## Jeanie Bourke - Re: 30 Monument St. Bp#2014-02773

**From:** Jeanie Bourke  
**To:** Brewster Buttfield  
**Date:** 3/6/2015 1:29 PM  
**Subject:** Re: 30 Monument St. Bp#2014-02773  
**CC:** George Froehlich; Jamie Isaacson; Tammy Munson; Tom Landry

Thank you for providing these changes and details. I have reviewed the information, see my comments below in red. This will need to be submitted formally as an amendment to the original permit. The application is the Residential Alterations/Additions, and you can reference the permit in the description along with the additional changes.

SECTIONS

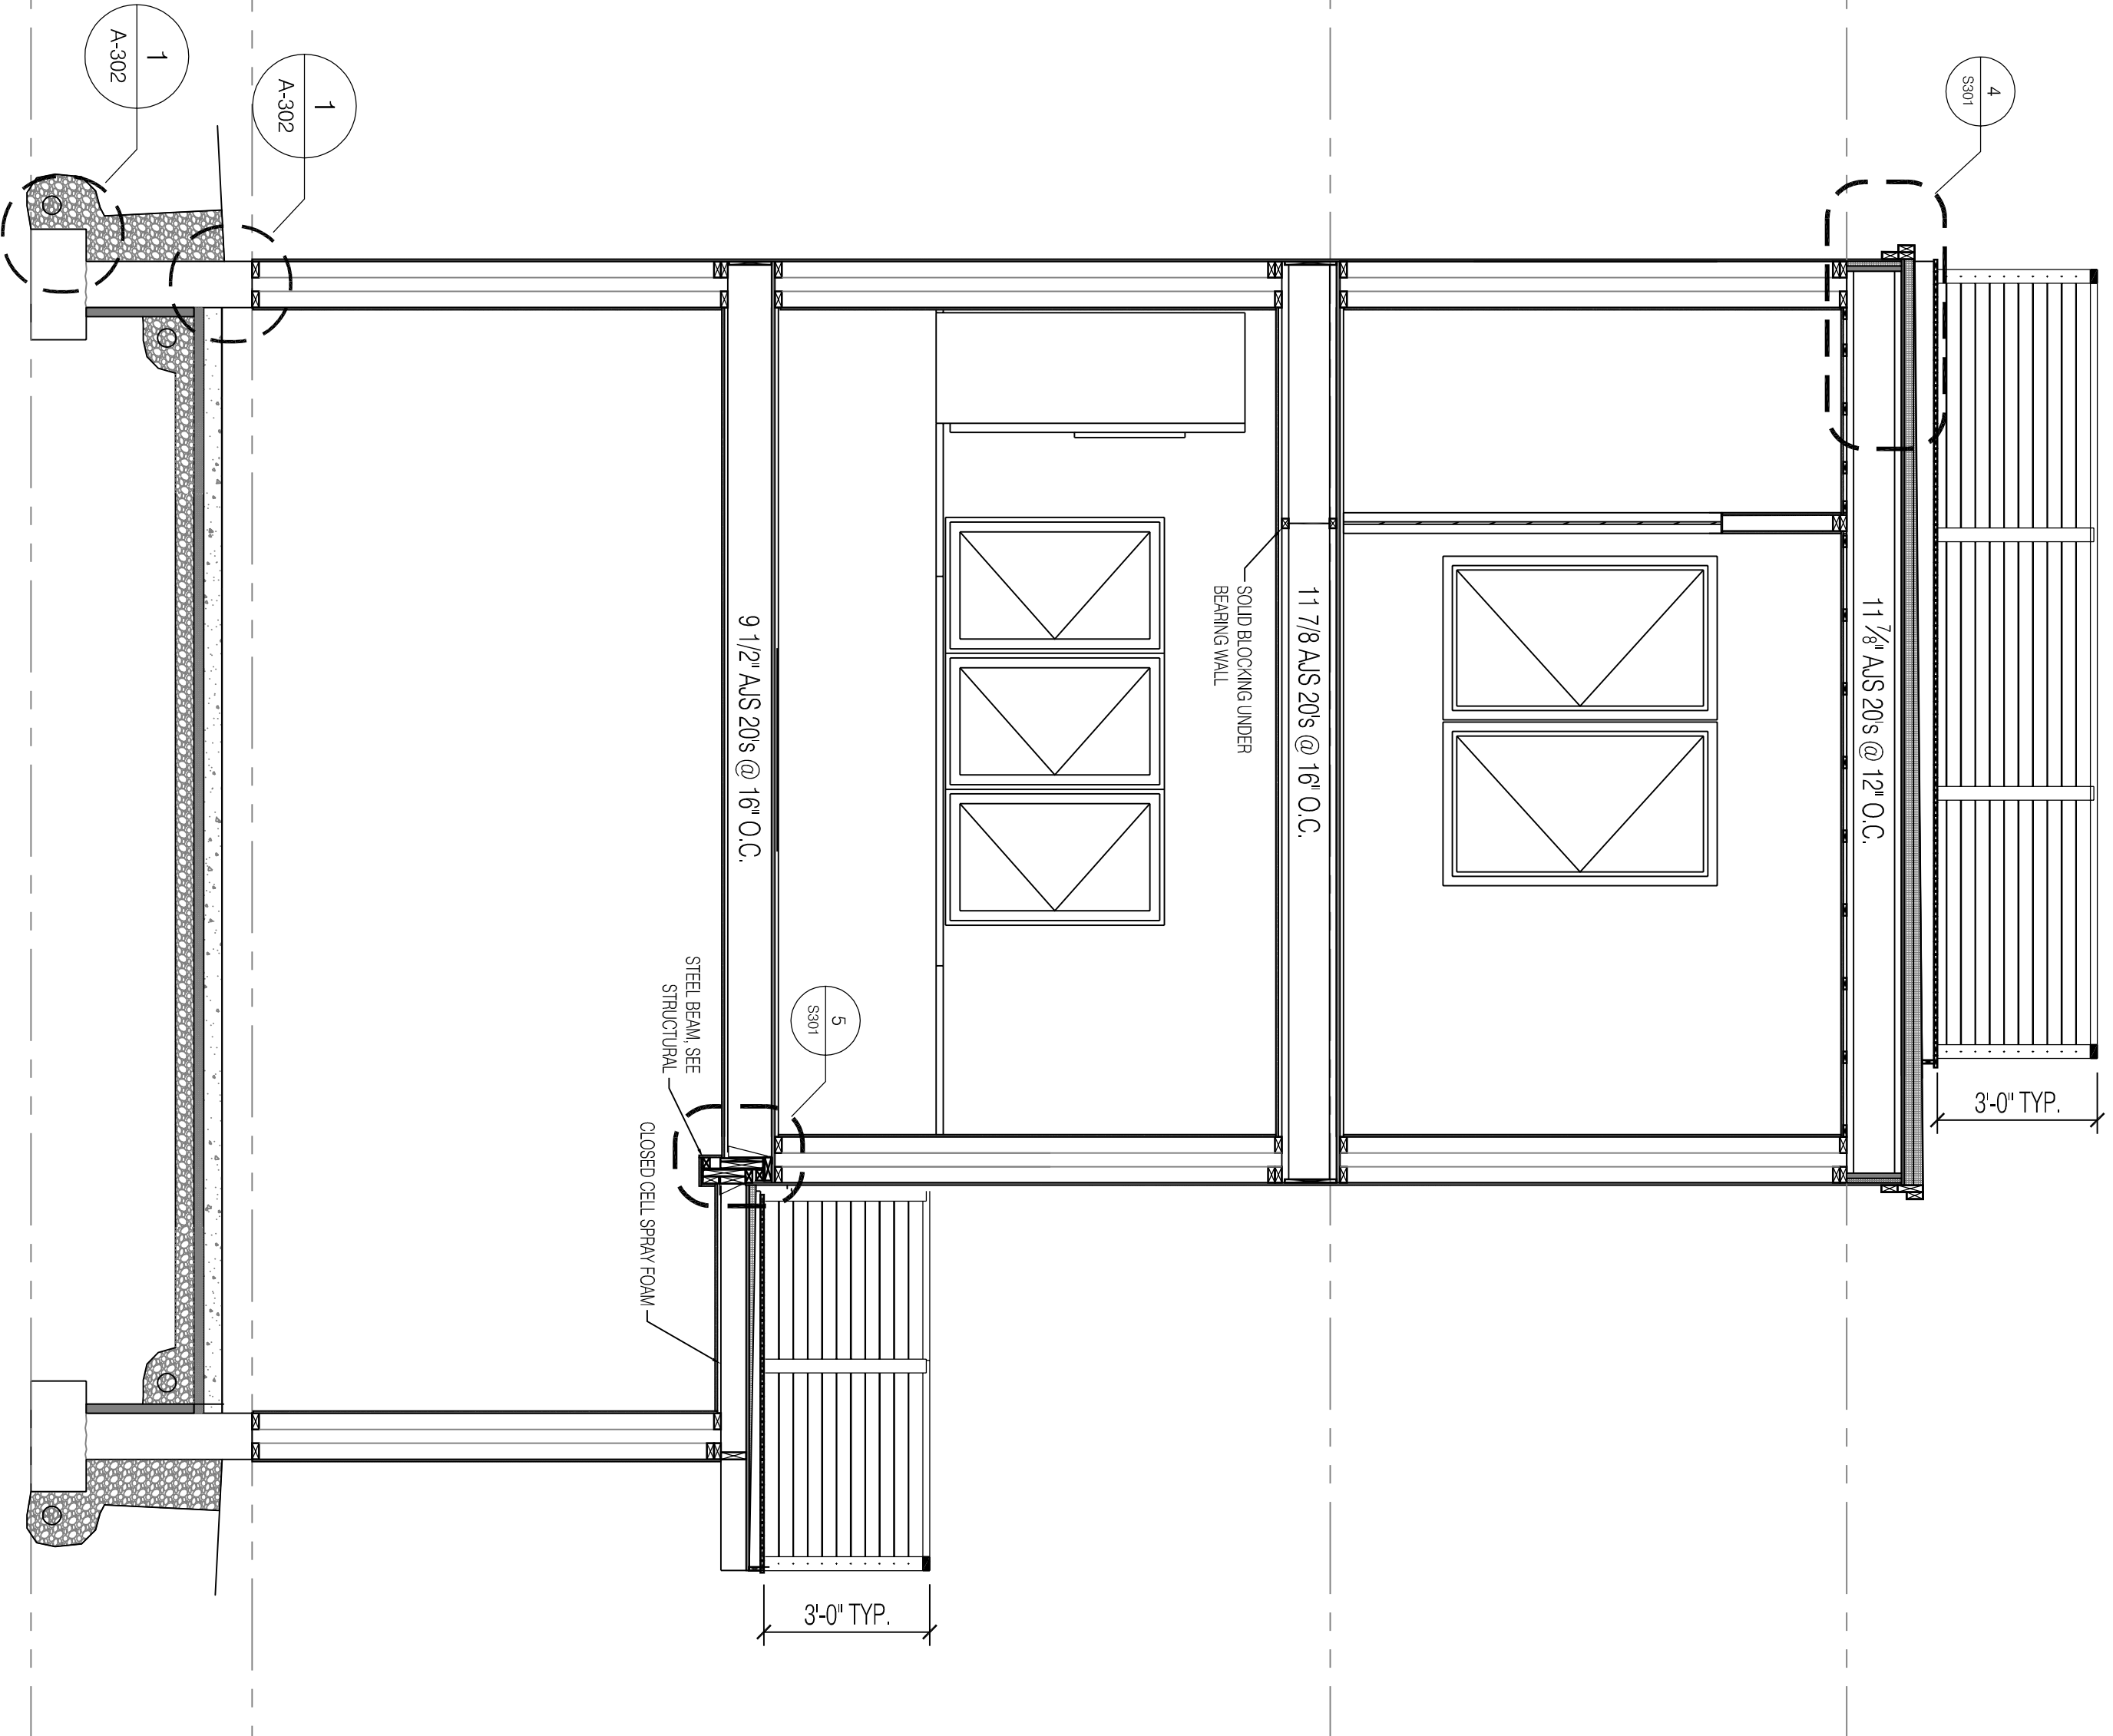
3. An updated plan for the deeper basement is a new sheet, A-103. It shows the required egress well, the stairs to basement instead of a hatch and the required thermal barrier for the insulation. This, as well as any other changes need to be updated on all associated plans, ie. sections, etc.

EXISTING ELEVATIONS

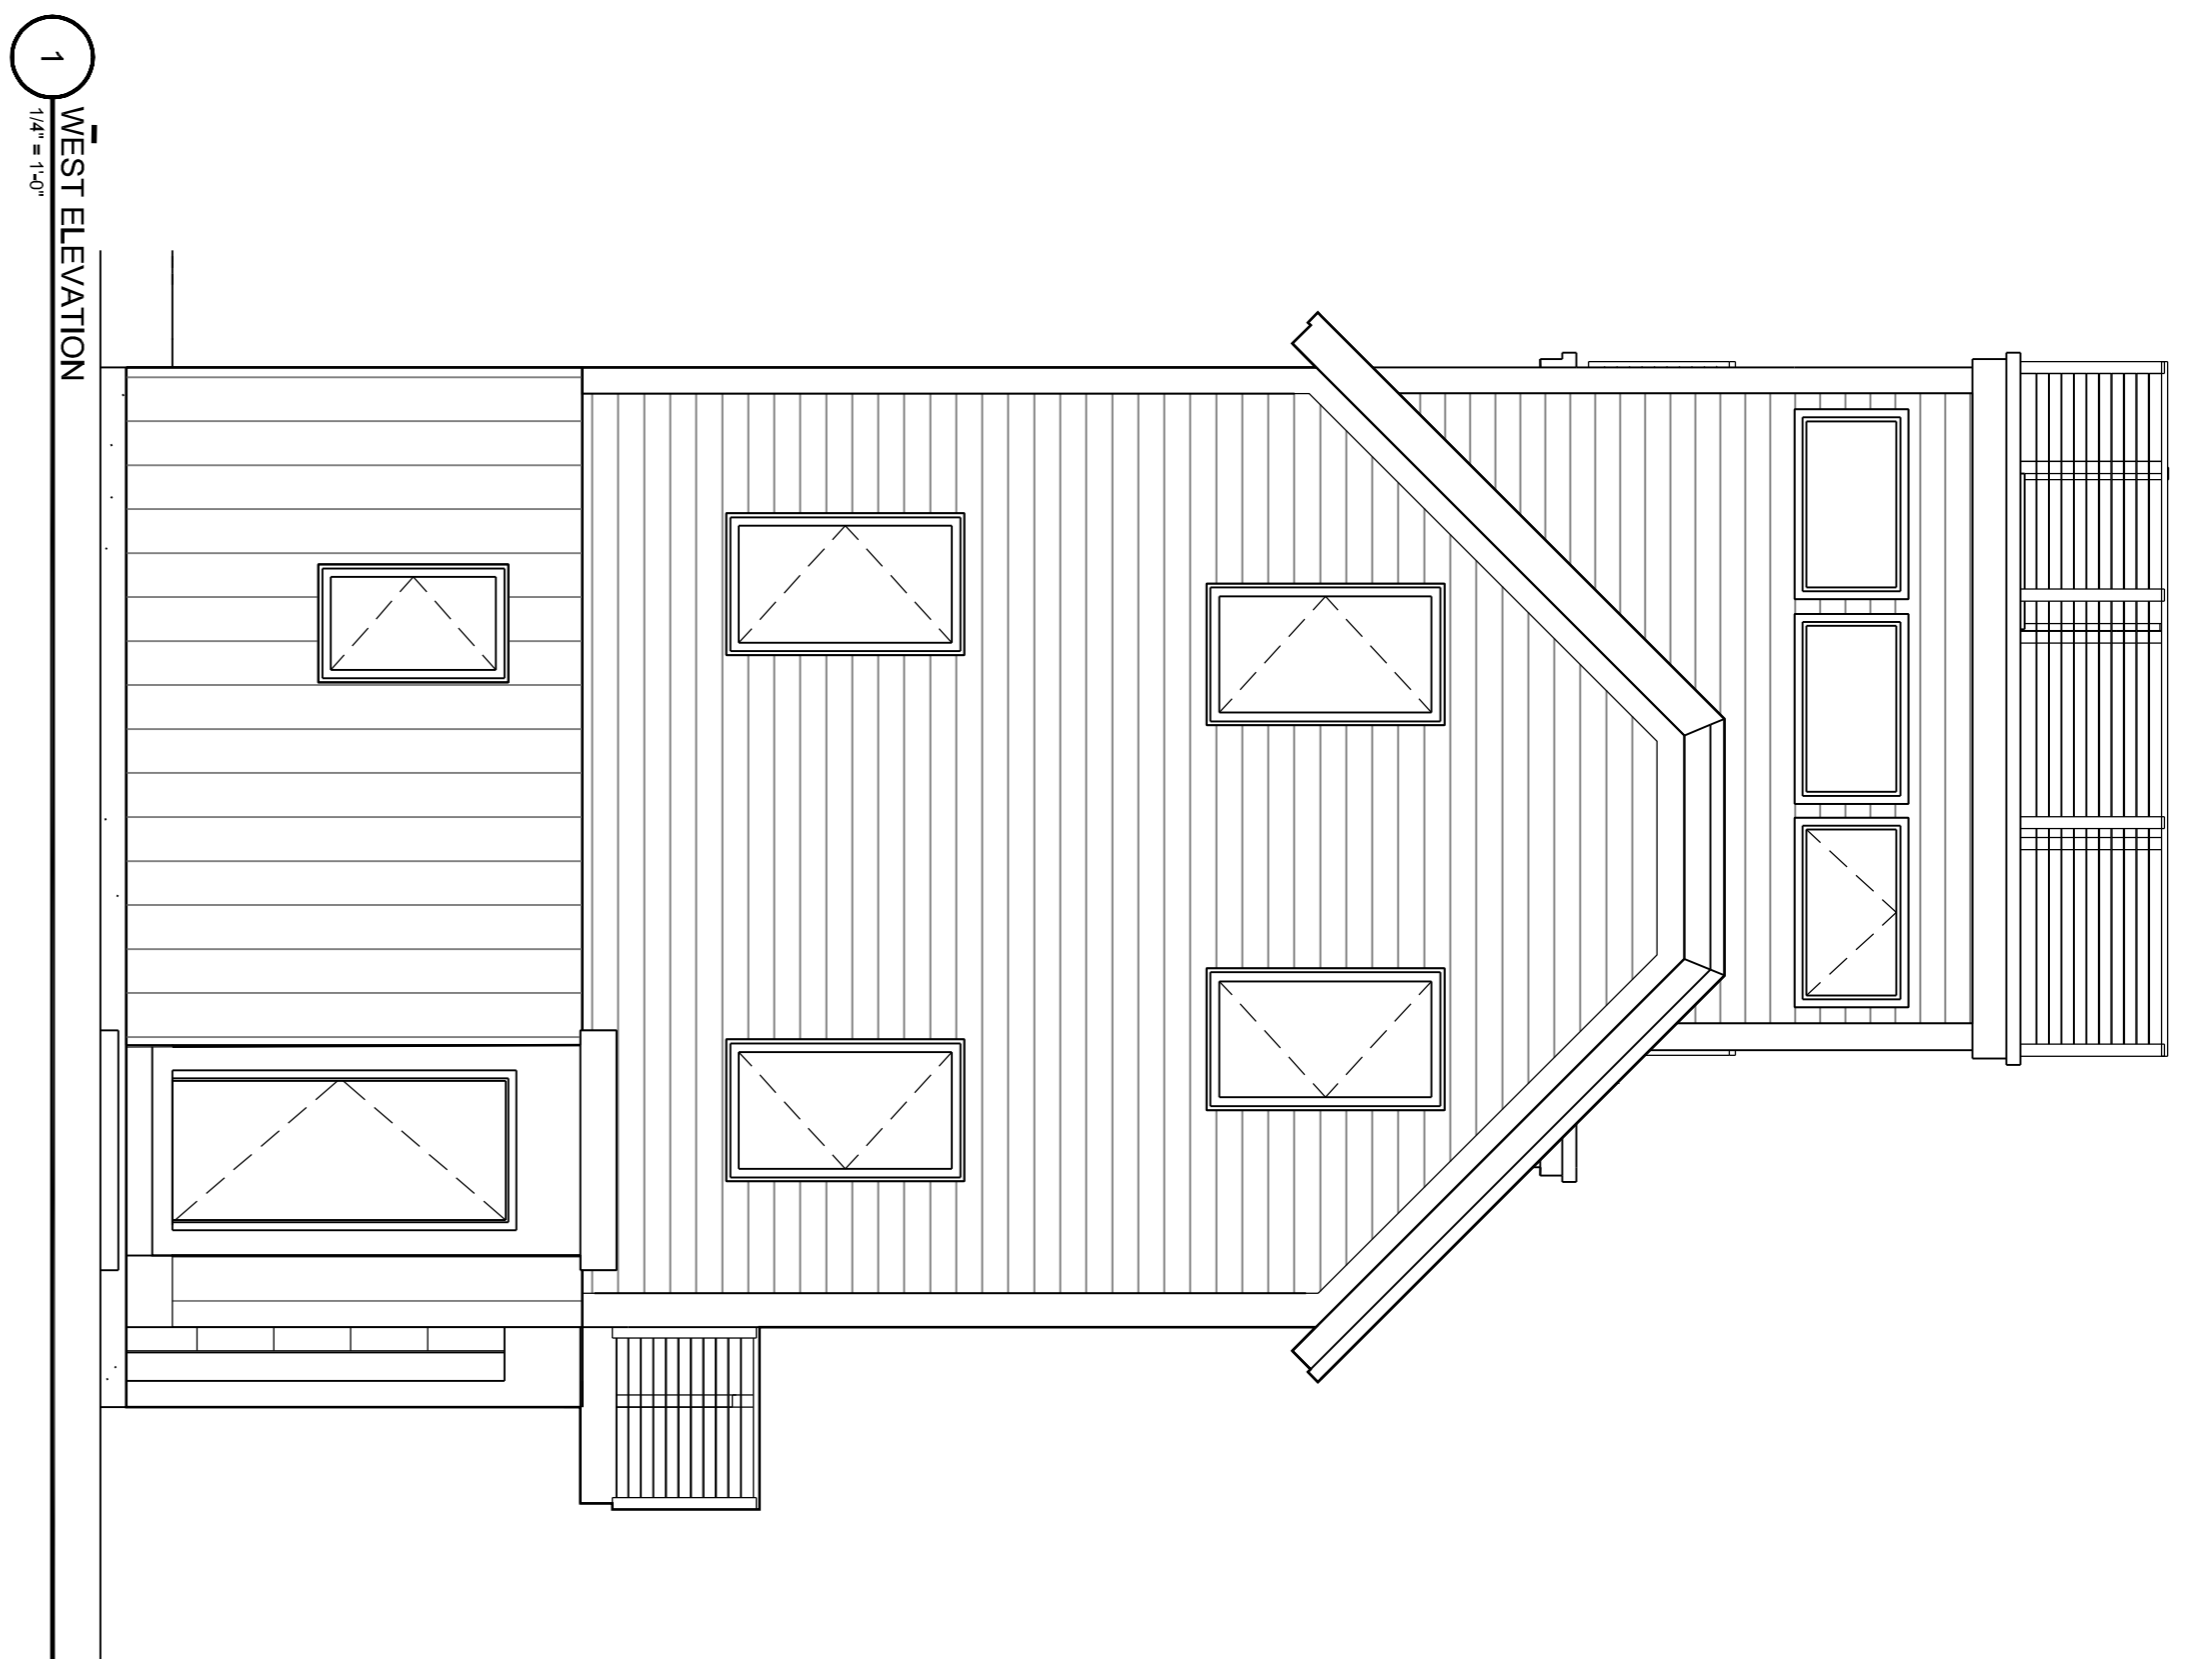
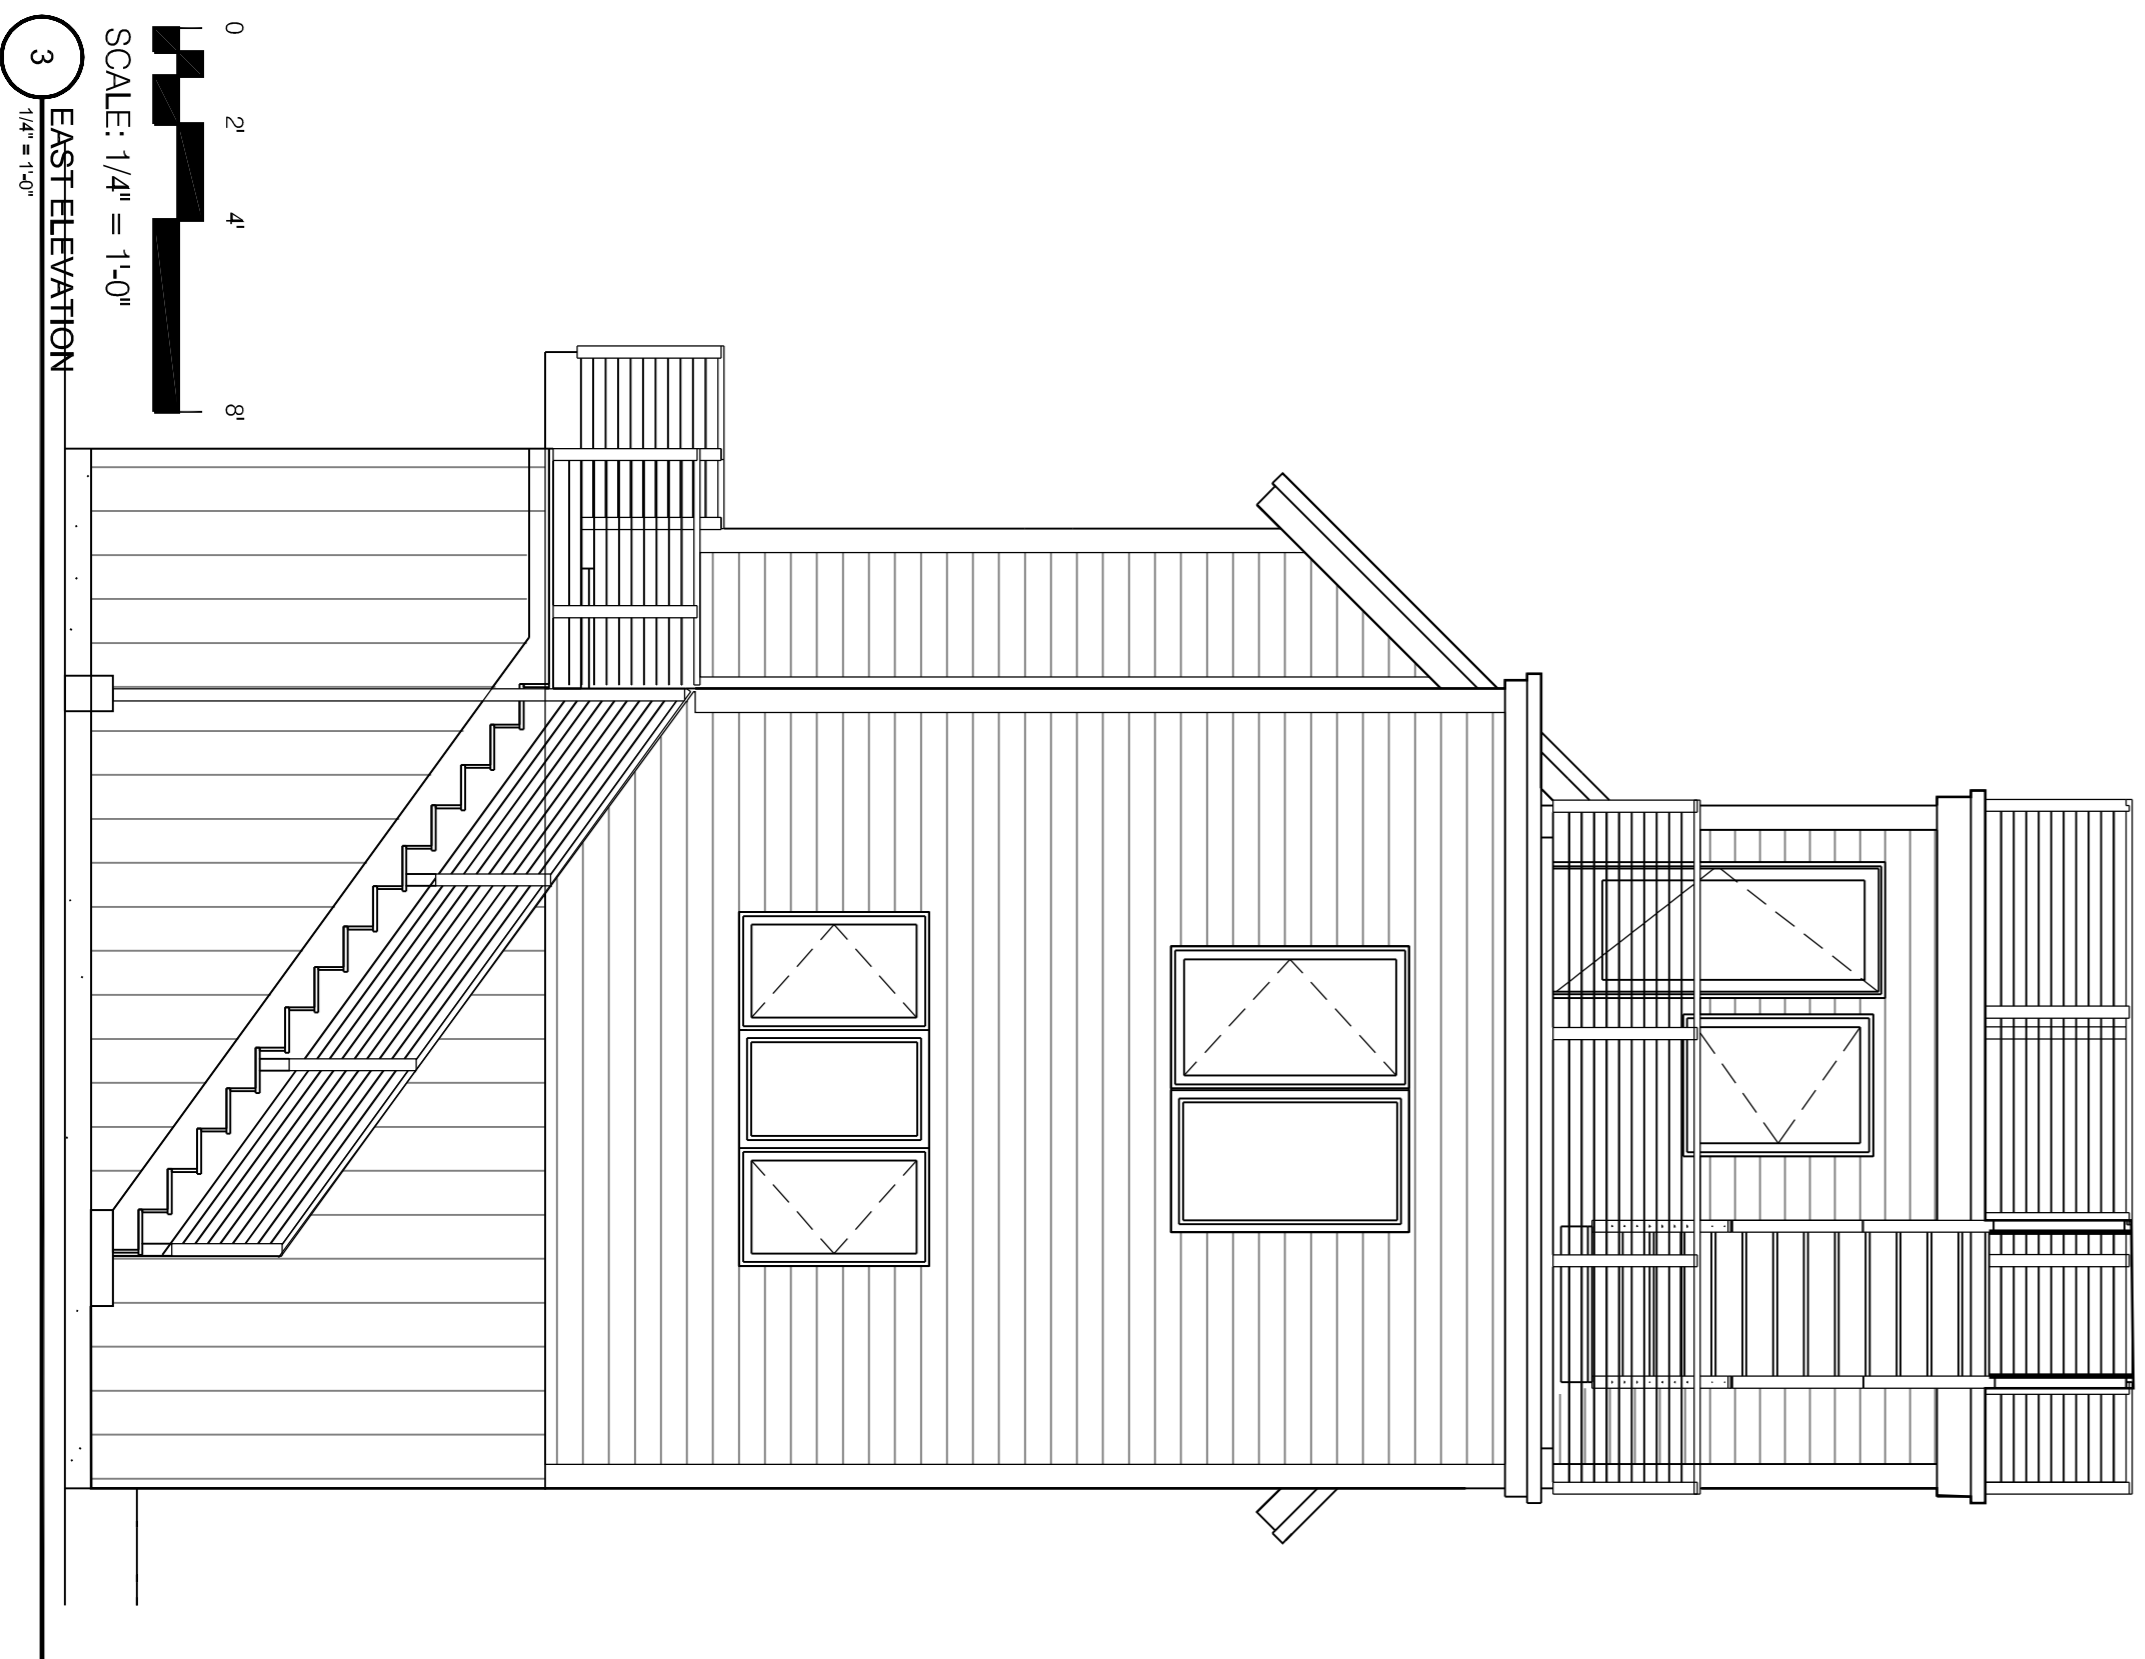
2. The window quantity is actually the same if you can the original basement windows (see photo below). The actual area of glass is reduced in the proposed plan by 17 sq.ft. This is shown on the existing and proposed elevation drawings. This is acceptable.

1. Provide a 1 hour exterior wall detail, rated from both sides per Table 302.1 and UL 263 for the northeast wall.
2. Provide the percentage of glazing & openings of the existing and proposed northeast wall. With this
